**Lead Local Flood Authority
Ground Floor
Northleigh
County Hall
Chichester
West Sussex
PO19 1RH**

**CM/19/26/PL - Baird Business Park, Grevatt's Lane, Littlehampton
BN17 5RE**

Erection of replacement commercial building, parking and other associated infrastructure, including new attenuation pond. This application is in CIL Zone 5 (Zero Rated) as other development.

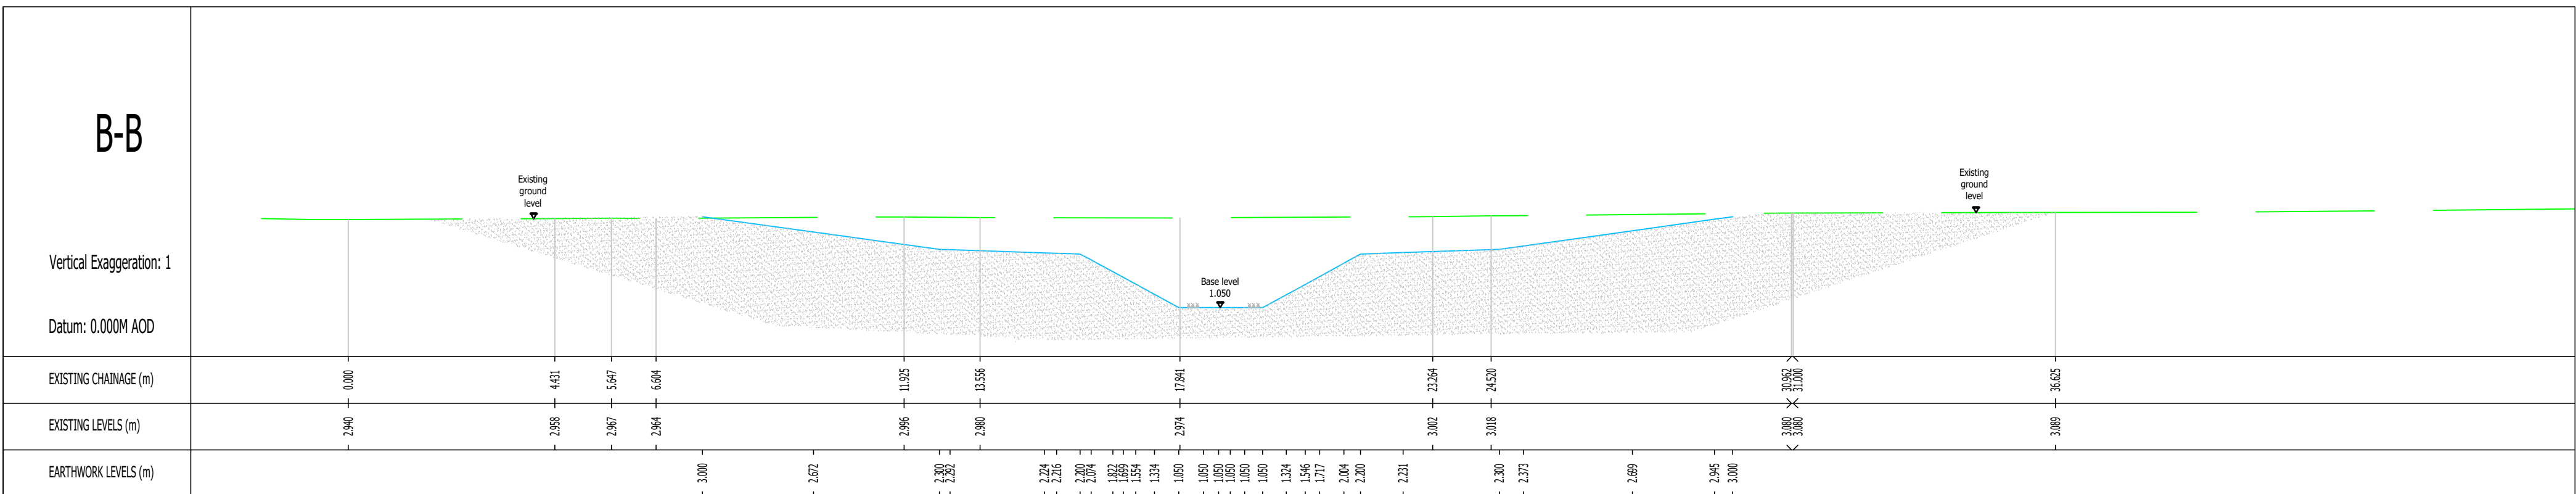
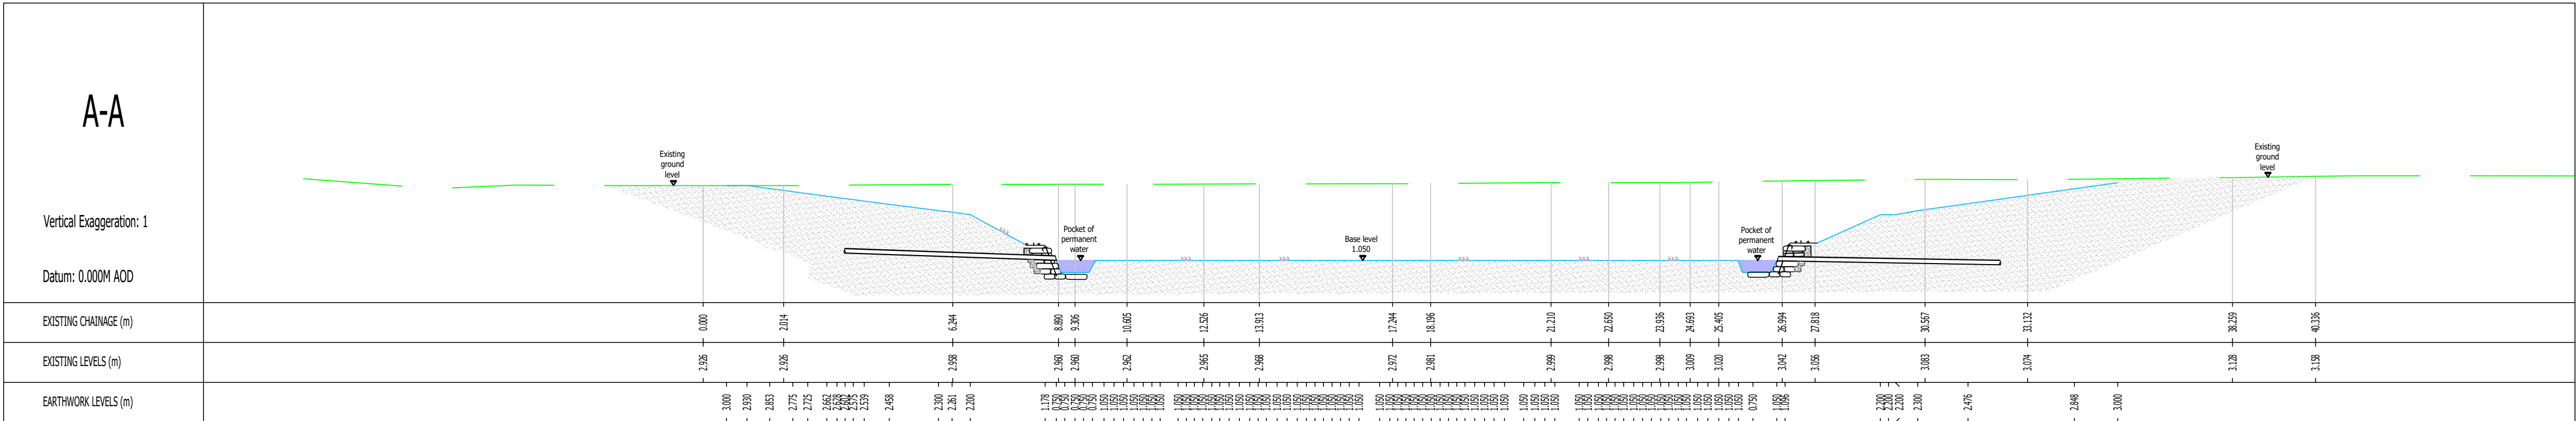
4. Level of detail design. For a full application the status of design would not be expected as preliminary. Plans should be sufficiently detailed (at or near construction) and be referenced and labelled accordingly.

- I. The drained area is 0.237ha which appears to include only the building roof and adjacent permeable parking spaces. Has the proposed access road been considered. It would be useful to have a complete drained areas plan indicating all impermeable areas within the boundary and the proposed drained area for the new drainage system and appropriate calculations revised to match.
- II. The proposed basin appears in a location within or adjacent to surface water flood risk, and potentially fluvial flood risk. An assessment of the with climate change surface water flood risk extent should be included to demonstrate the basin is outside of the 1% AEP extent for fluvial and pluvial sources as required by the National Standards for SuDs.
- III. The proposed surcharged outlet basis and level may be sufficient however the surcharge is not demonstrated by the hydraulic calculations.
